From: Sue Howell
Sent: 28 February 2019 14:49
To: Planning.Responses
Cc: Michael Eastham
Subject: FW: Planning Consultation on WA/99/18/DOC

Further to submission of revised landscape details contained in dwgs CSA 3823-101-111 Rev B in relation to Condition 9 of this application WA/99/18/DOC I can recommend the following:

APPLICATION NO: WA/99/18/DOC

Site Address: Land East of Tye Lane Walberton Arun

D01 1.8m high brick wall

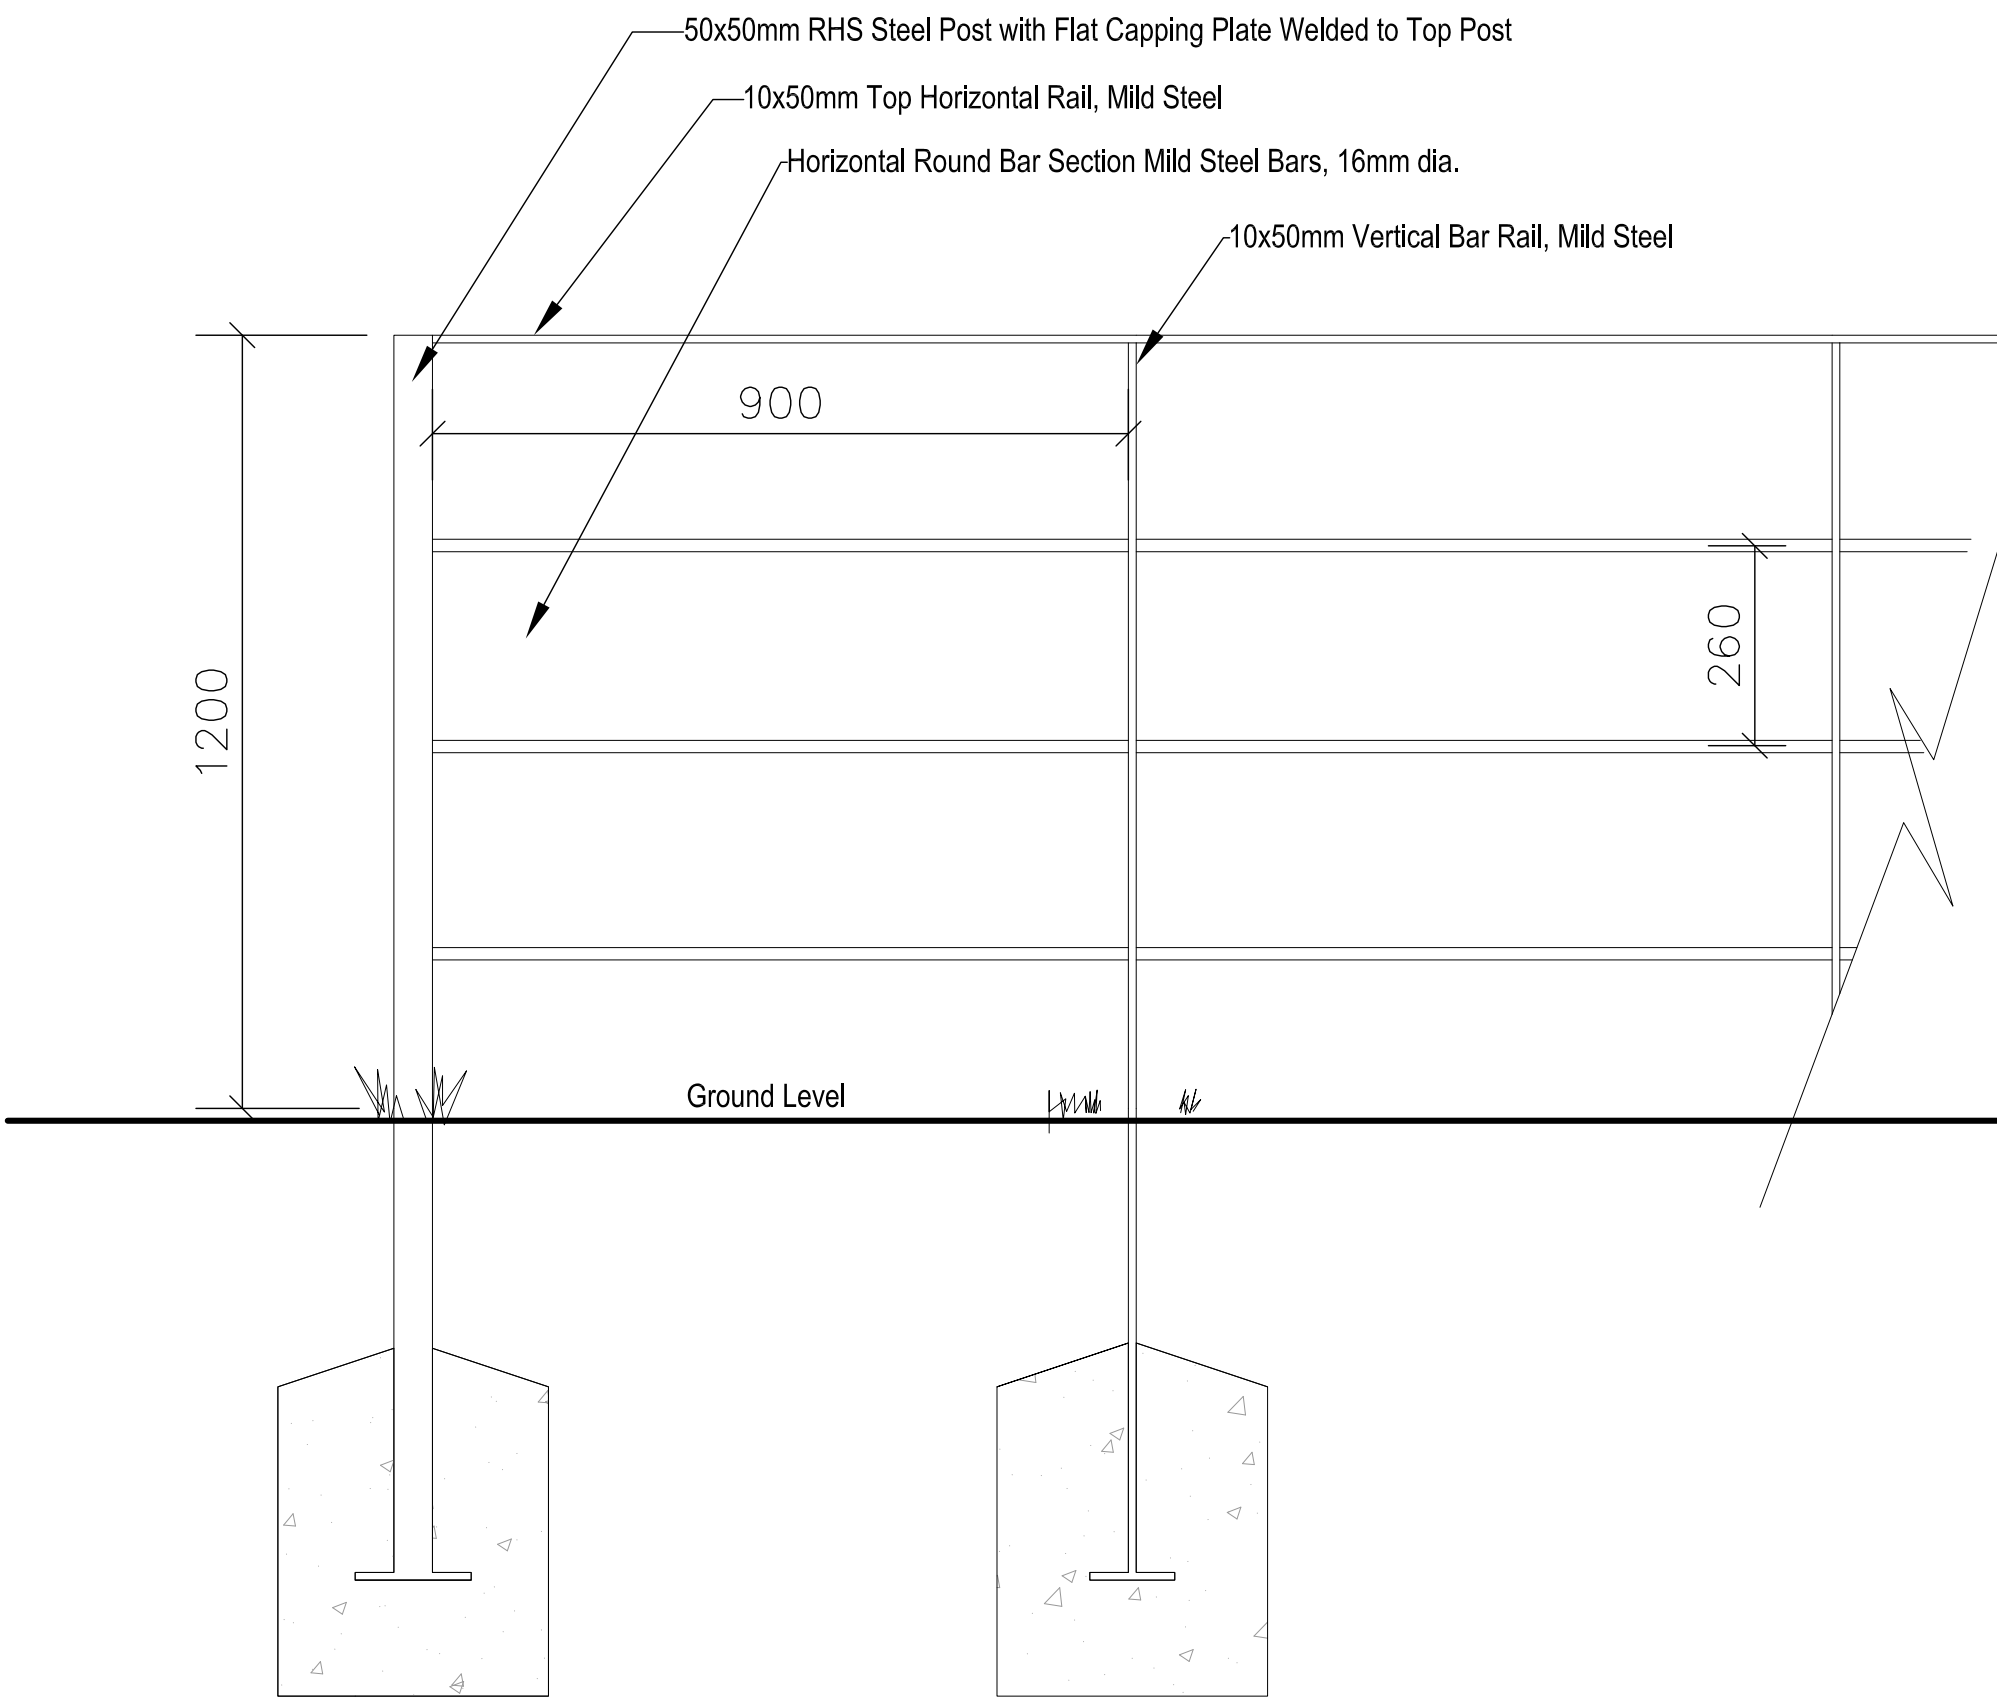
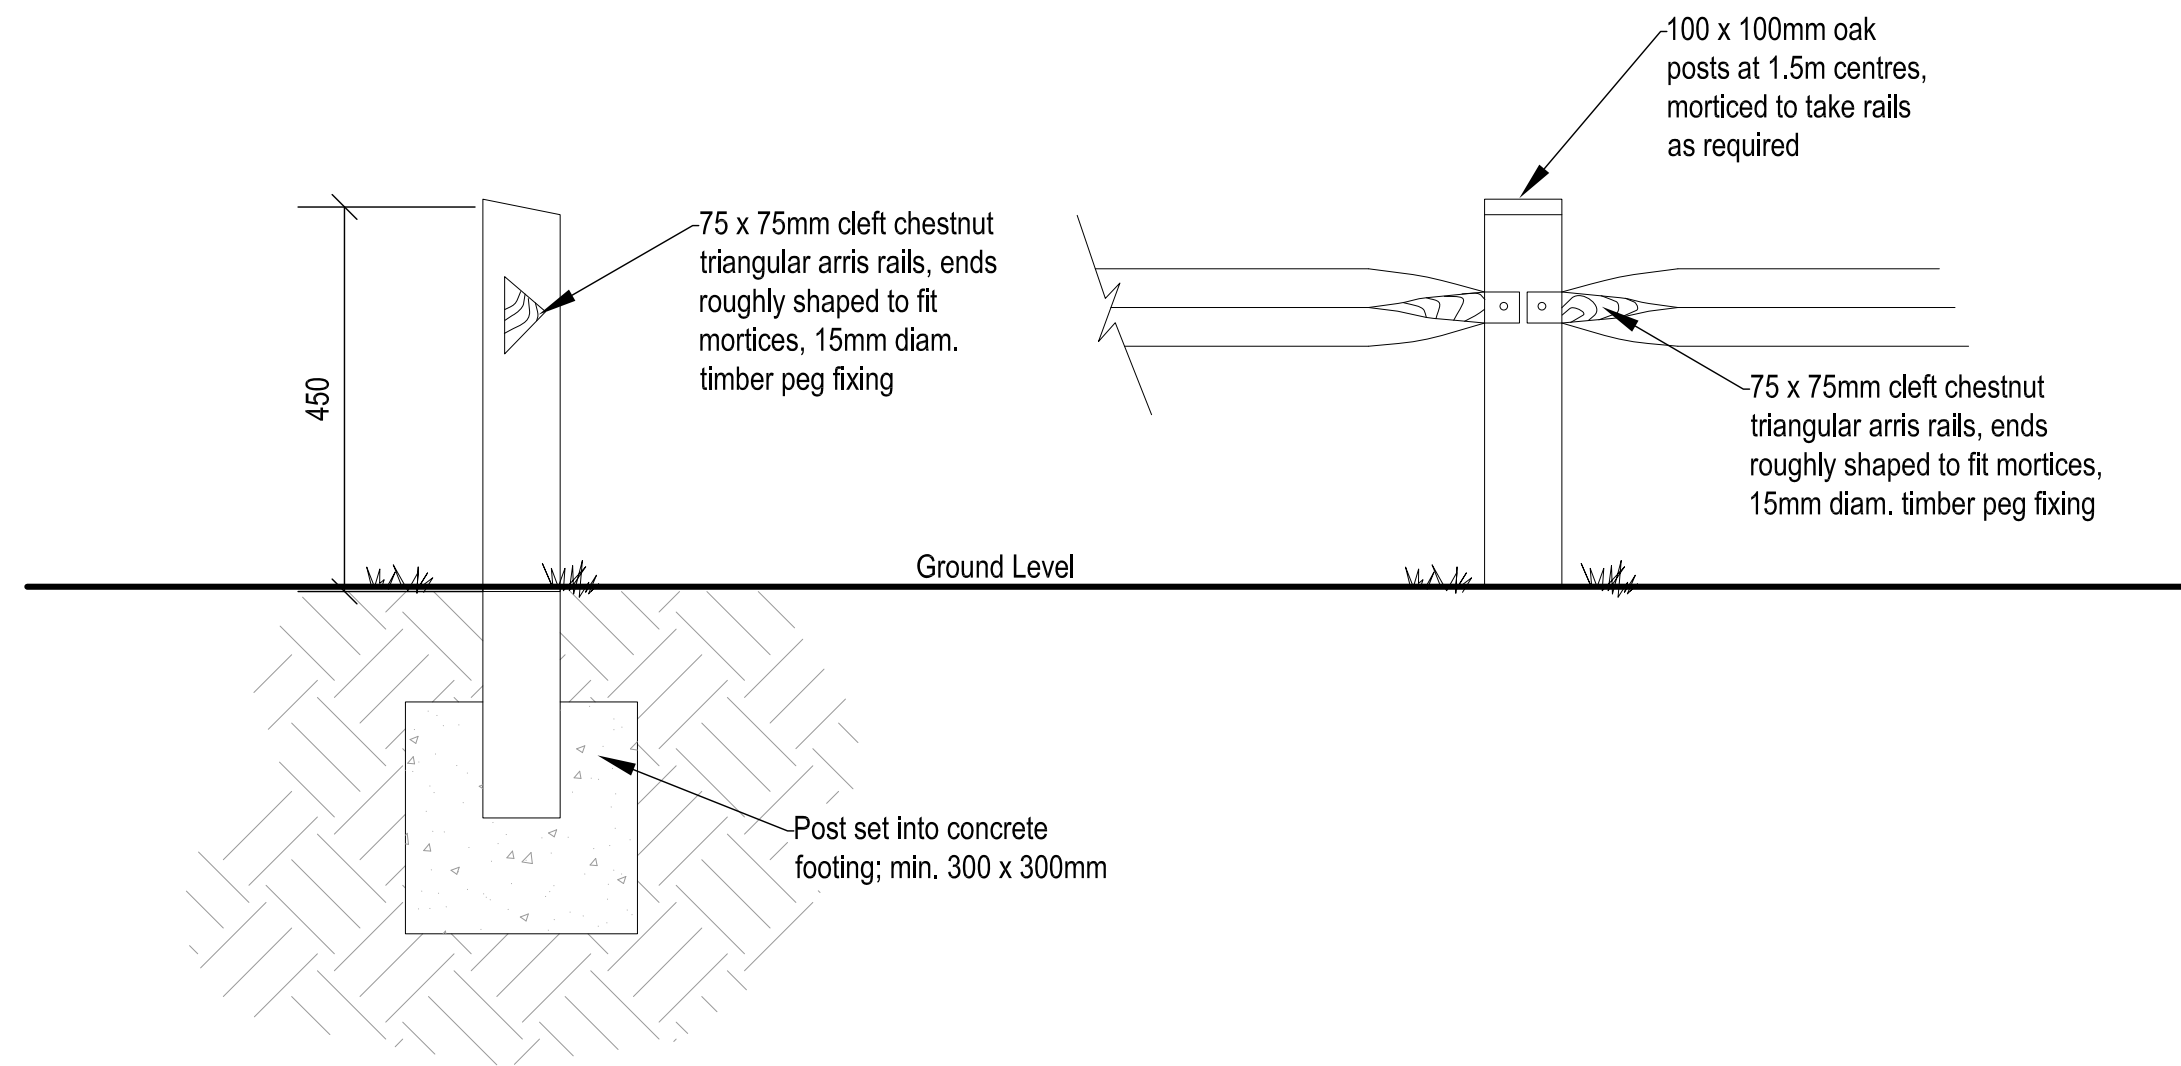
- II. Details re height, design and type of boundary treatment have been provided.
- III. Crown spread and location of trees to be retained have been shown in location within masterplan and detailed landscape drawings and the topography in which these sit.

I would therefore **recommend discharge of Condition 9** landscape details contained in this reserved matters application WA/95/18/RES following outline consent WA/44/17/OUT.
